Our Ref: 15756
DPE Ref: SSDA 7317 MOD 6

SSD 7317 MODIFICATION 6 - RESPONSE TO REQUEST FOR FURTHER INFORMATION

This letter has been prepared by Ethos Urban on behalf of Mirvac Projects Pty Ltd (Mircvac) to respond to the Request for Further Information issued by the Department of Planning & Environment (the Department) on 16 May 2018 in relation to Modification 6 (MOD 6) to State Significant Development (SSD) 7317.

title
General Arrangement Plans 1:250
Lower Ground

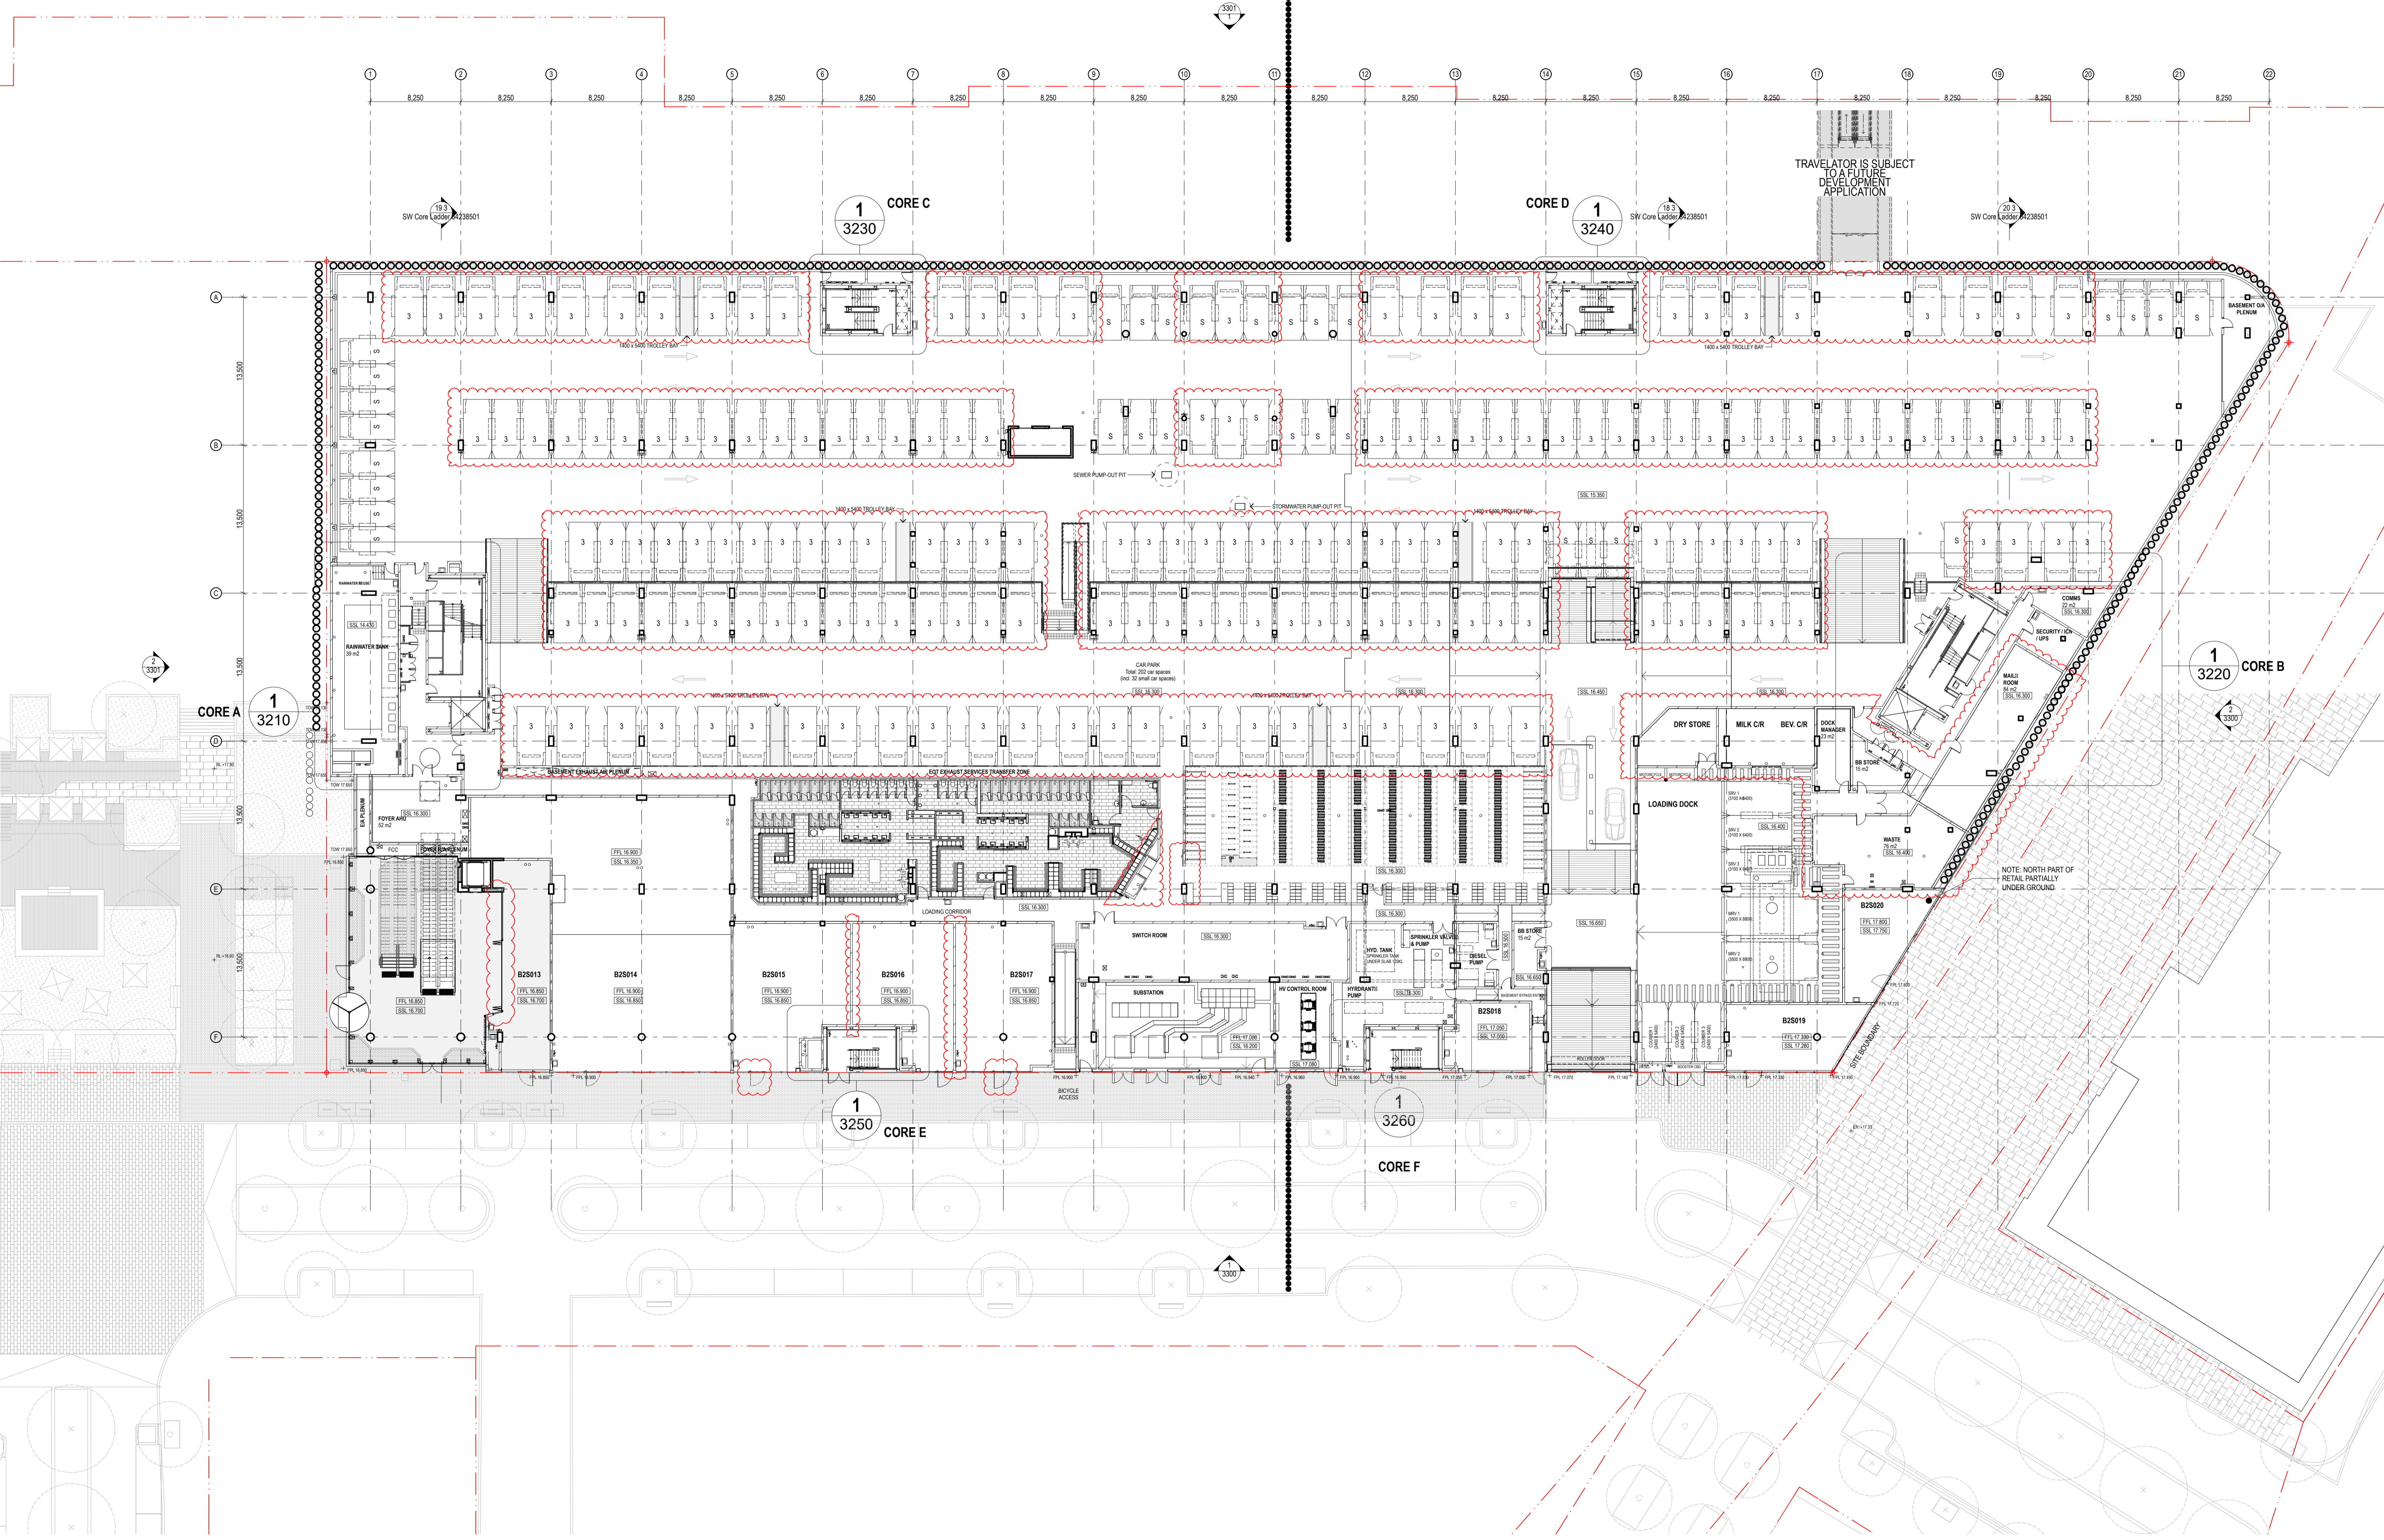
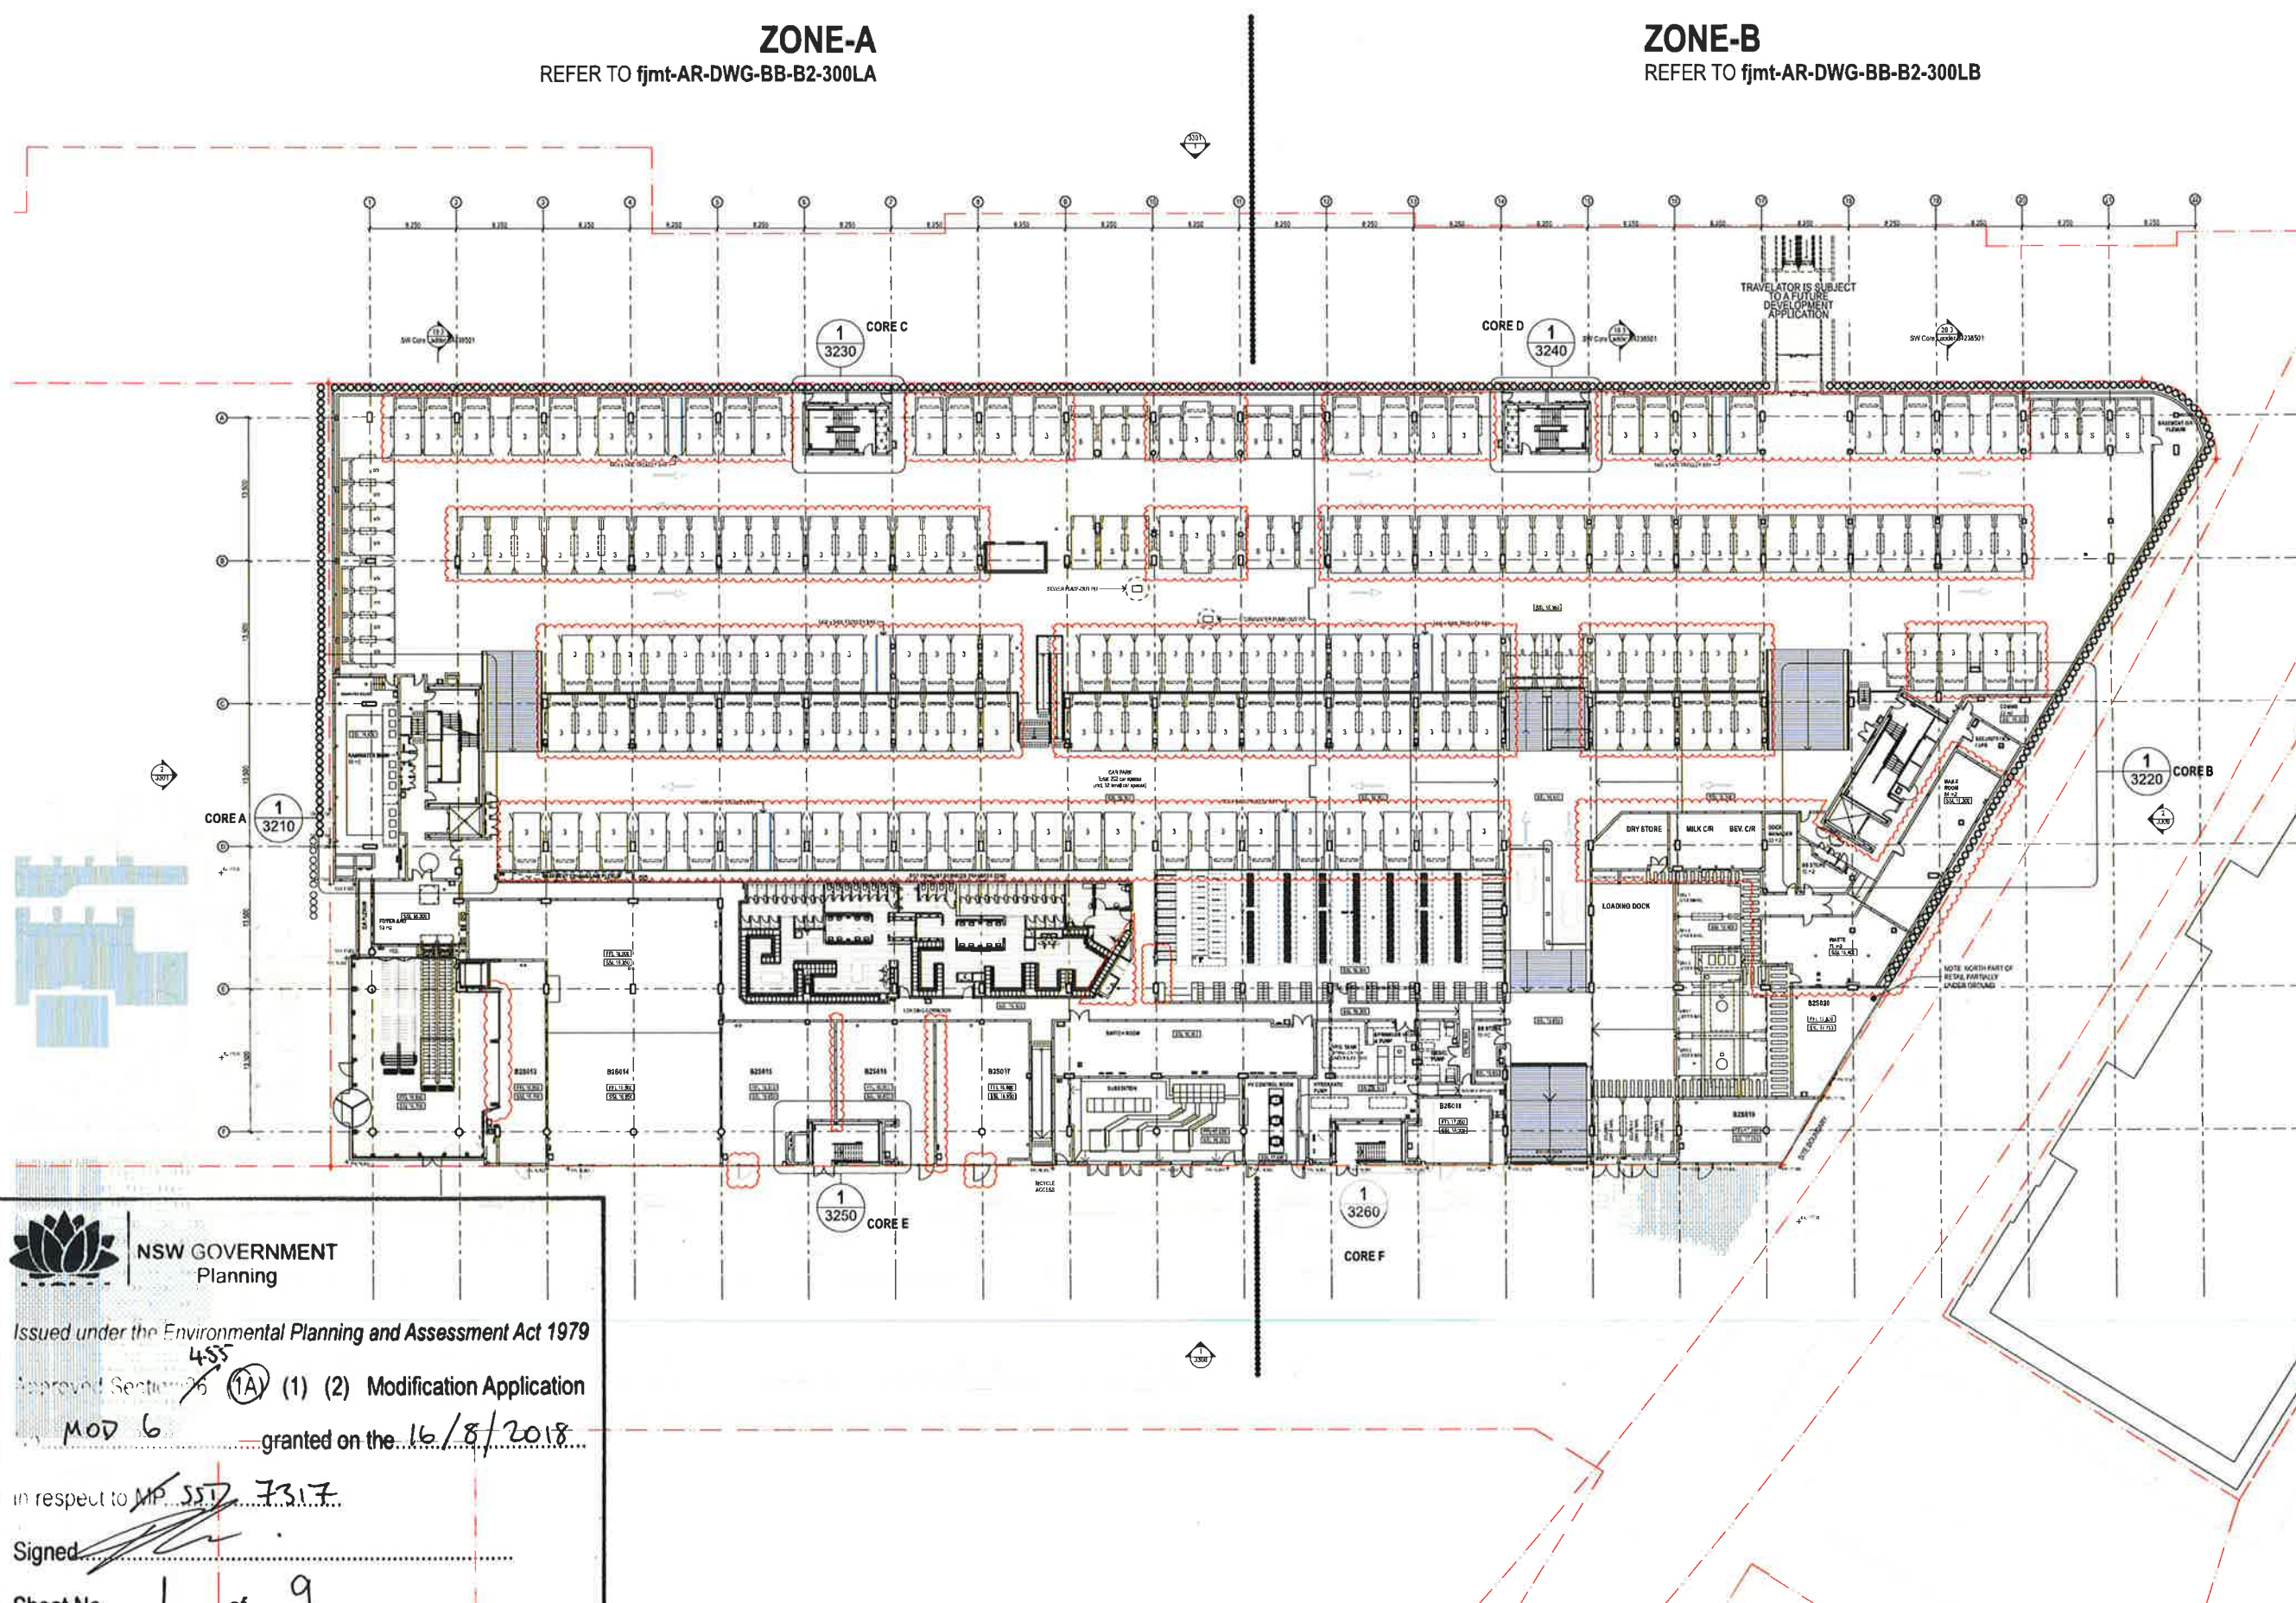
Address the proposed change to the parking with regard to Condition G8 of the development consent SSD 7317.

Condition G8 required the car spaces within Buildings 1 and 2 to only be used by employees and visitors of Buildings 1, 2 and 3. Given that the Lower Ground Floor level of Building 2 is to be used by visitors to the ATP precinct and the Locomotive Workshop, as explained in the original Modification 6 application letter and above, approval to amend Condition G8 is required to be amended as follows:

*G8 The car parking spaces in Building 1 ~~and Building 2~~ shall only be used by employees or visitors of Building 1, Building 2 or Building 3. The car parking spaces **in Building 1** shall not be used as commercial commuter car park.*

General Arrangement Plans 1:250
Upper Ground

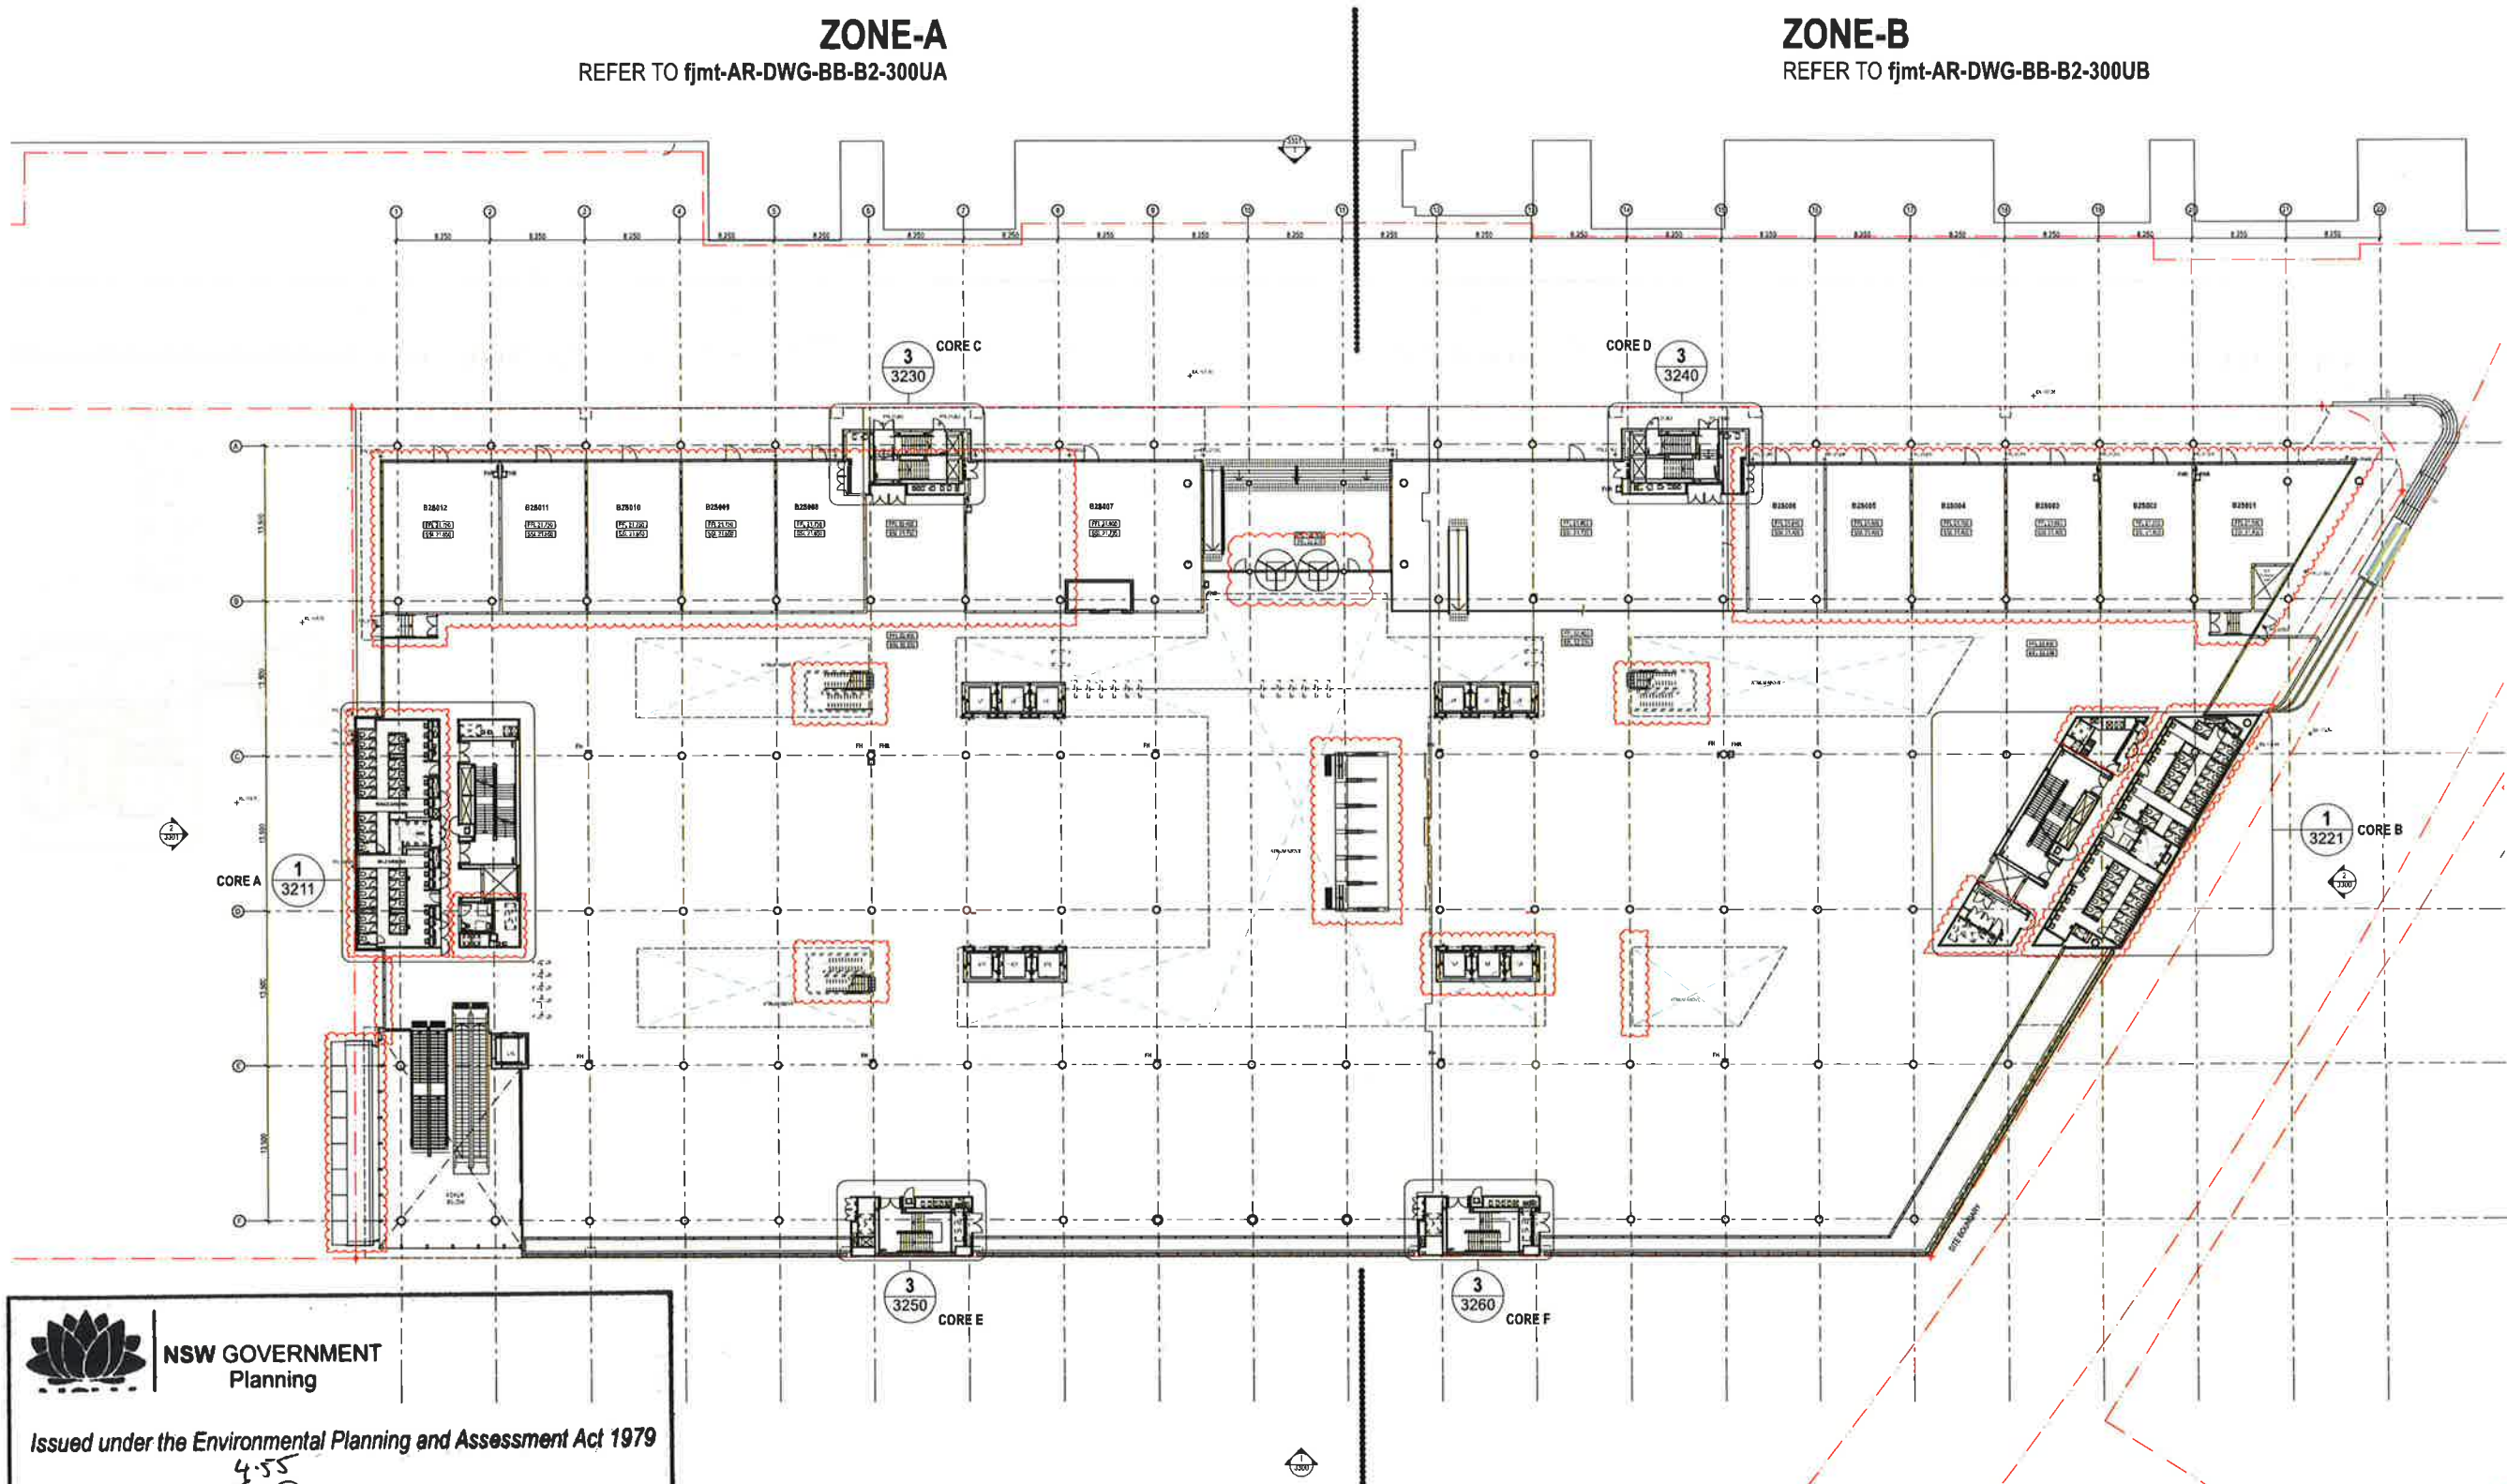
Clarify the new location of the feature stairs on the Upper Ground Floor Level, noting that these are proposed to be relocated.

The amended location and revised design of the feature stairs is shown in the Architectural Plans at the Upper Ground Floor and Level 1 within **Attachment A**. They are also highlighted by a red box in **Figures 1 – 2**.
